KITTTITAS COUNTY COMMUNITY DEVELOPMENT SERVICES

Subject: Evergreen Ridge (LP-18-00002) Final Plat – Staff Review and Request for Additional Information

TO: All Staff
FROM: Justin Turnbull, County Surveyor 
DATE: May 2, 2018
SUBJECT: County Survey Review of PUD Plat LPF-18-00002 (Evergreen Ridge)

SUBJECT: LFP-18-00002 Evergreen Ridge PUD Parcel B Division 2

**EVERGREEN RIDGE P.U.D. - PARCEL B, DIVISION 2**  
**A PORTION OF THE NORTH 1/2 OF SECTION 12,**  
**TOWNSHIP 20 NORTH, RANGE 14 EAST, W.M.**  
**KITTITAS COUNTY, STATE OF WASHINGTON**

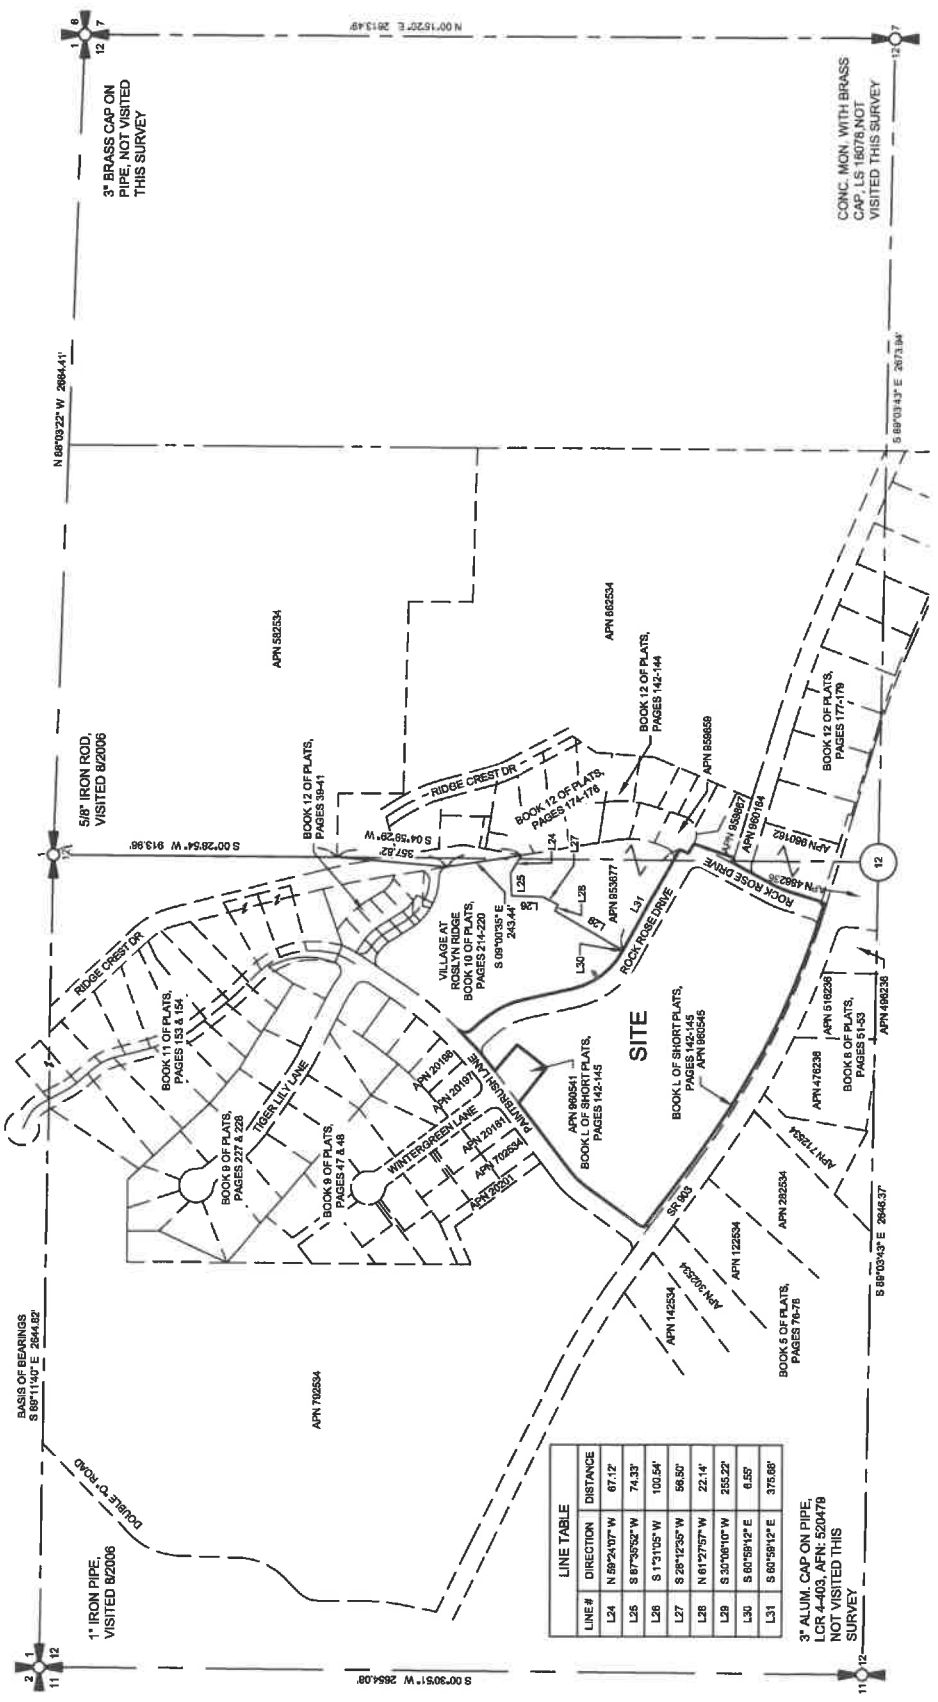
- Required Changes
 1. A cul-de-sac is required on Paintbrush Lane and needs to be shown on the face of the plat, due to the roadway not having direct access onto SR 903.
 2. The connection of Paintbrush Lane onto SR 903 should show that it is for emergency access only, not a thru route.
 3. Show Maywood Lane Road Tract.

- **Required Changes**
 1. Include reference to survey documents that identify difference corner positions. Along the East line of Paintbrush

Lane as it compares to B:9, V:47

214.83' shown, 215.62 of record

Along the North line of Rock Rose Drive as it compares to V:10, B:214 and V:10, P:185 R=309.74' shown, R=308.00 of record

2. Show Temporary Cul-de Sac on Paintbrush lane (per AFN:201803060001)
3. Show existing buildings on Lots 4A and 4E.
4. Include the Basis of bearing.
5. While not required for preliminary, the final submittal shall include dimensions of the curves of the access easement herein dedicated.
6. The plat notes include conflicting statements as to maintenance responsibilities for the access. Please correct. (Plat notes 5 and 8)
7. Please show the source of the file referenced in plat note 9.
